CITY OF ALBUQUERQUE

October 12, 2018

**Re: Del Webb @ Mirehaven Units 3 & 4
Grading and Drainage Plan Engineer's Stamp dated: 7/9/2018, Drainage
Report Engineer's Stamp dated 5/10/2018, and Amendment #1 to the
Drainage Report Engineer's Stamp dated: 9/18/2018 (H09D017G)**

CITY PROJECT NO.	ZONE MAP NO.	SHEET	OF
650482	H-8/9	5R	26

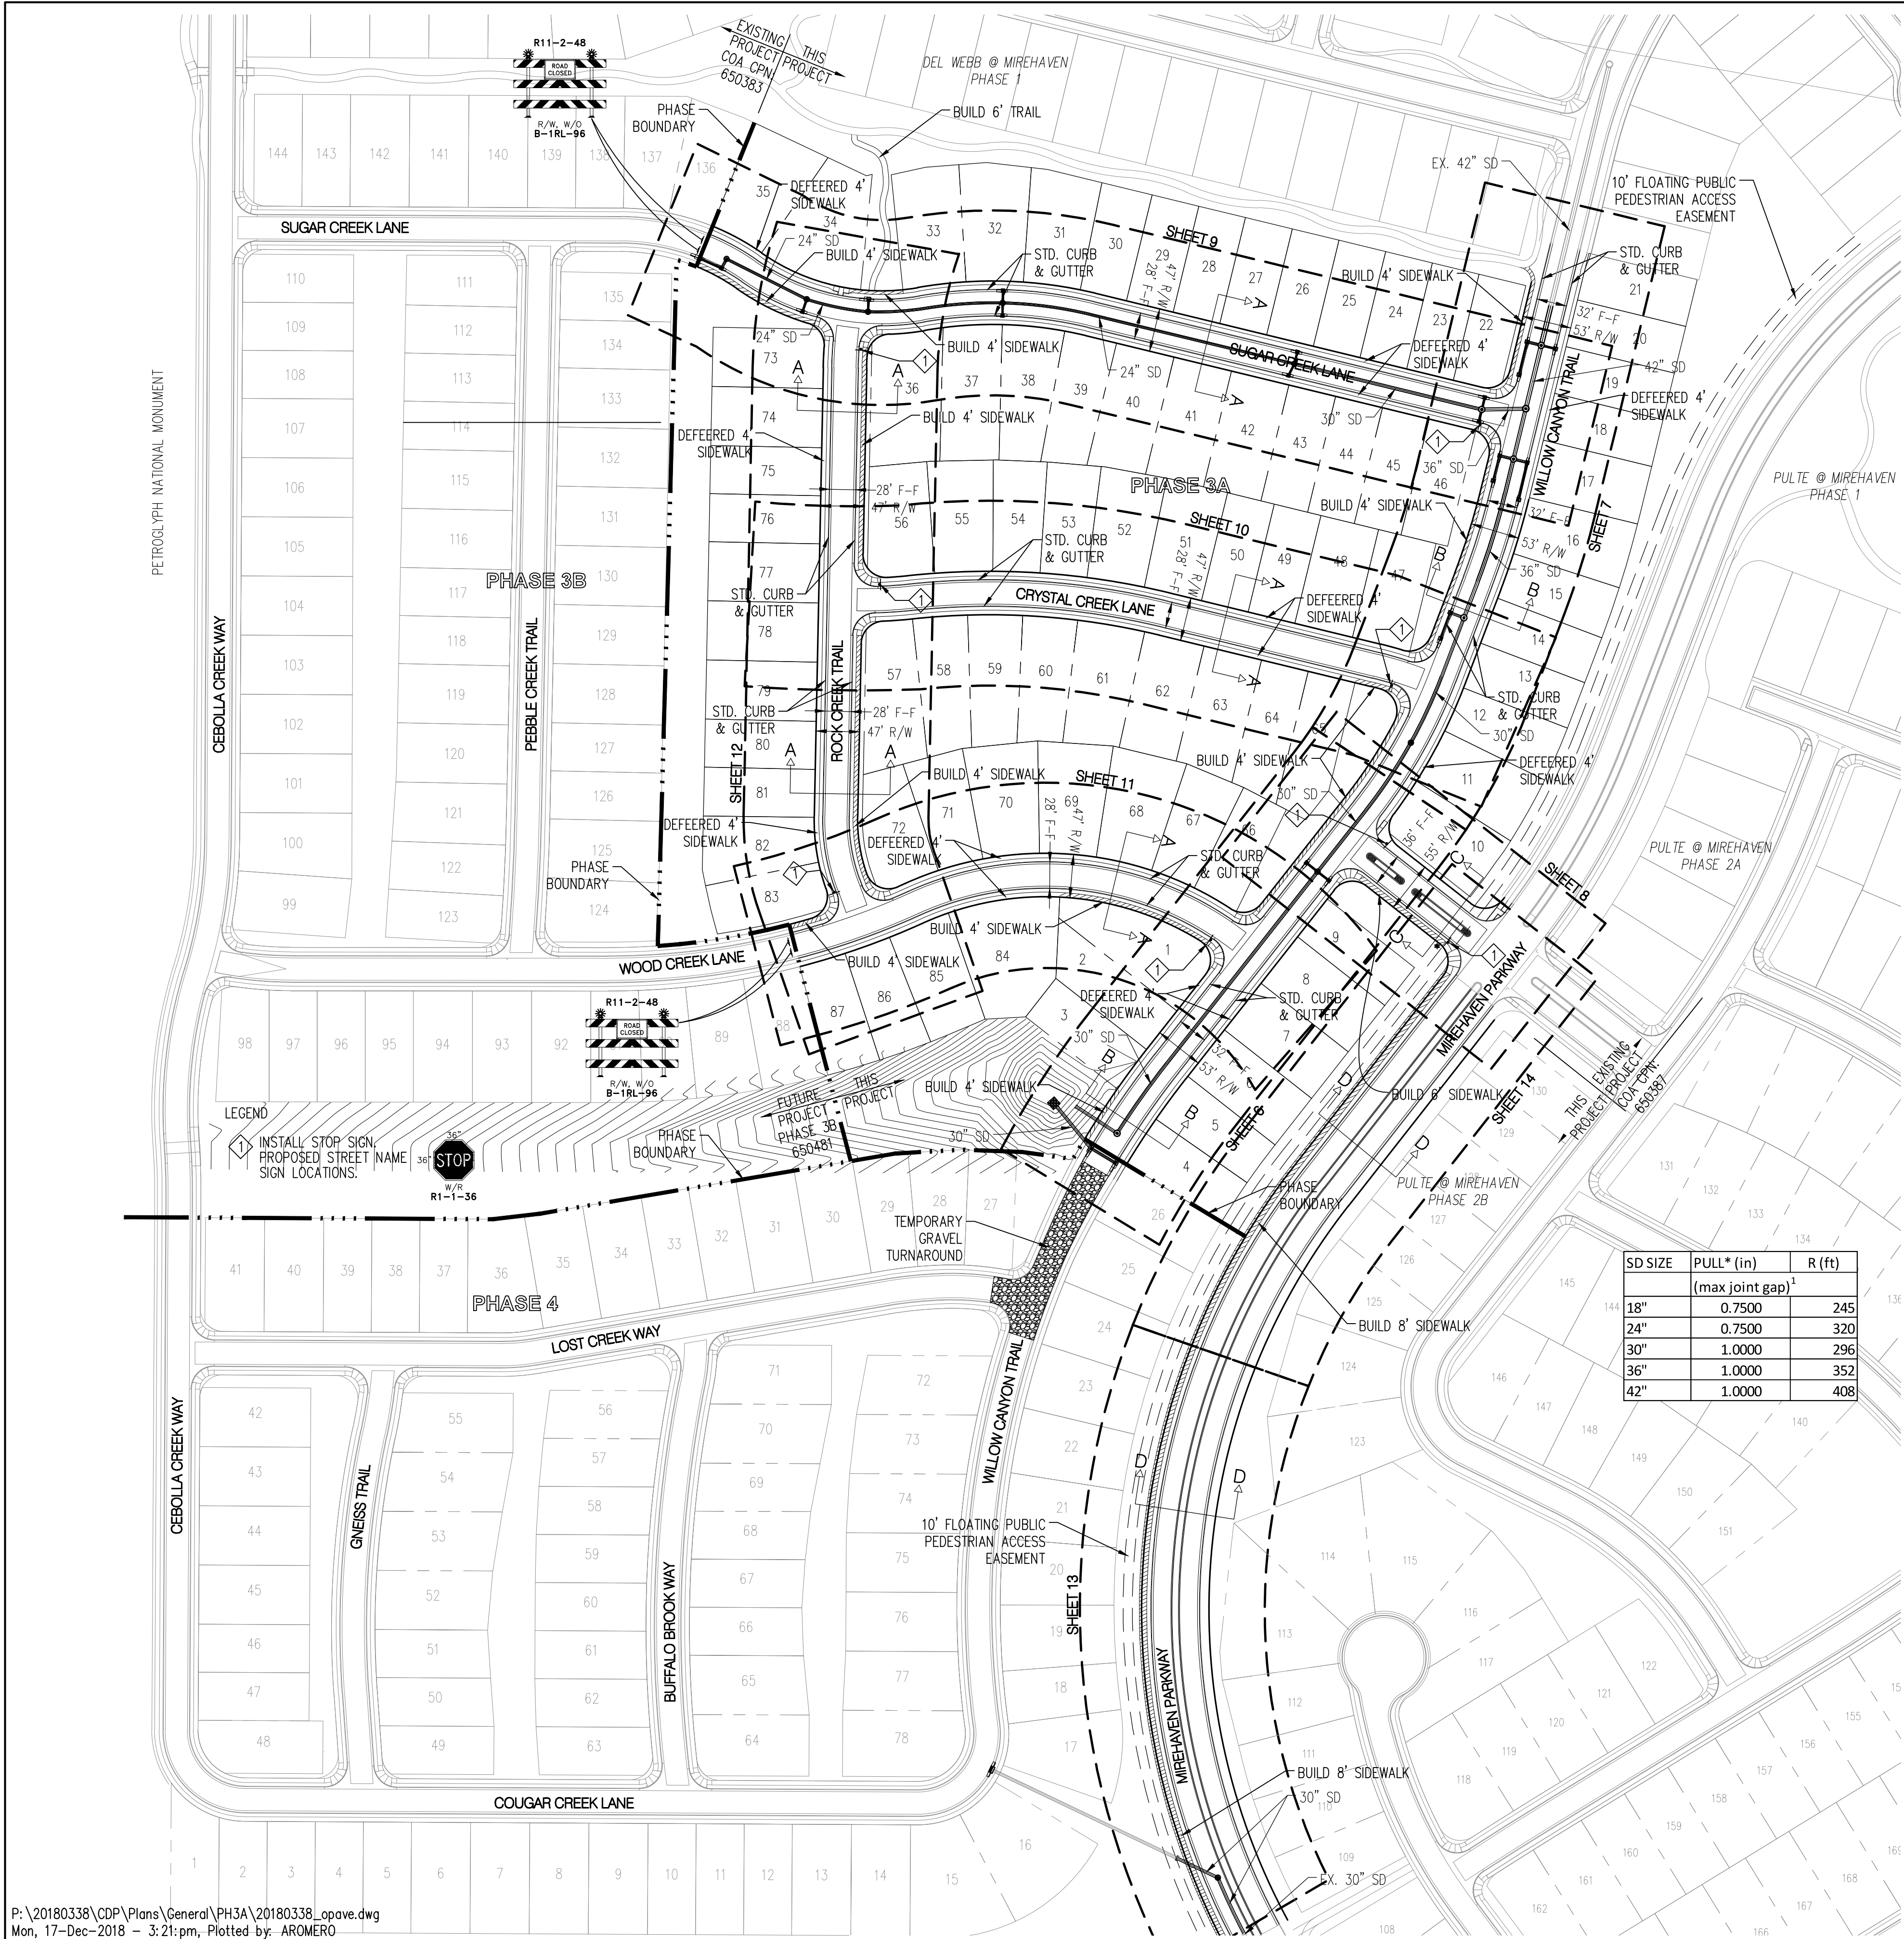
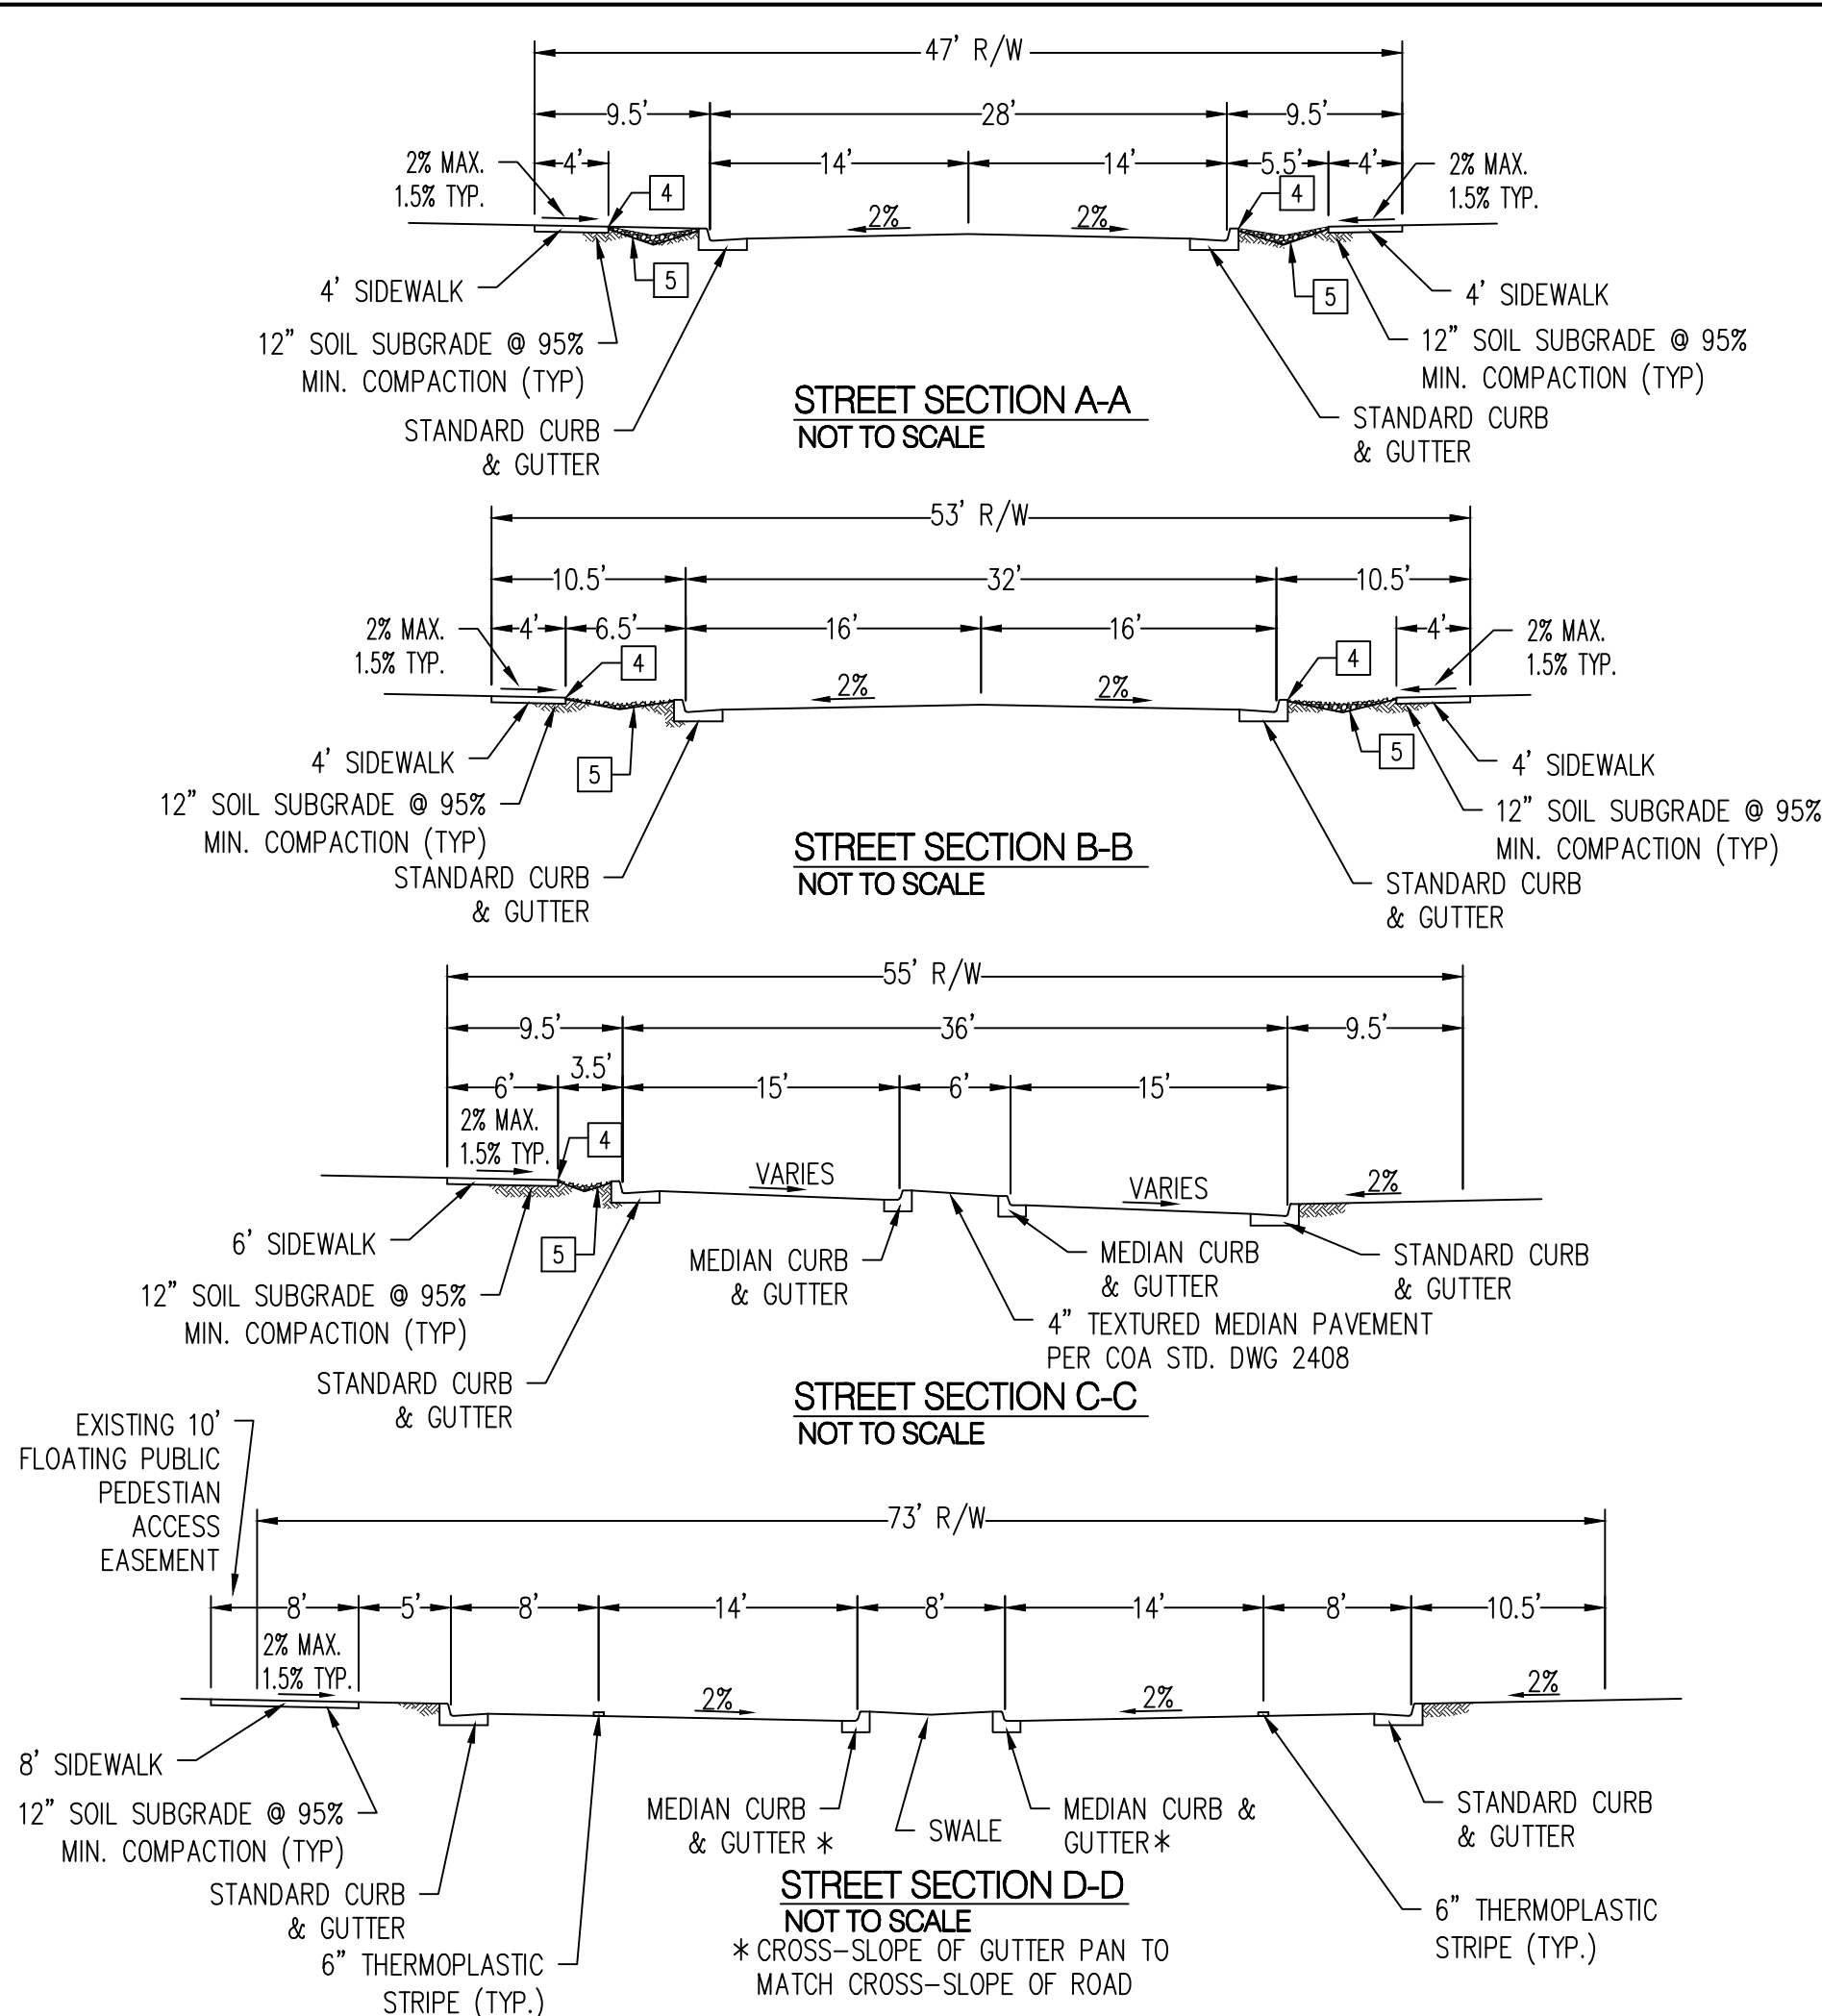
4. Label the inverts of the pipes, the top elevation of the baffle, the normal pool elevation and pond volume, the Q_{100} , and the 100 year water surface elevation on the grading plan and on the pond detail. The 100 year water surface elevation should be based on either weir depth over the baffle or inlet control on the outlet pipe whichever is higher plus losses between the pond and inlet. The calculations and an explanation of the calculations are required in the amendment. A section showing the length of the weir should be added. Hydraulic calculations must be contained in a bound report with an engineer's stamp and signature on it.

5. The invert of the pipe into the pond should be set at the invert of the pond, or provide a concrete rundown between the end of the pipe and the invert of the pond. Riprap is not sufficient to stabilize the slope when subject to concentrated flow and should be only used in the flat part of the pond bottom. Specify the
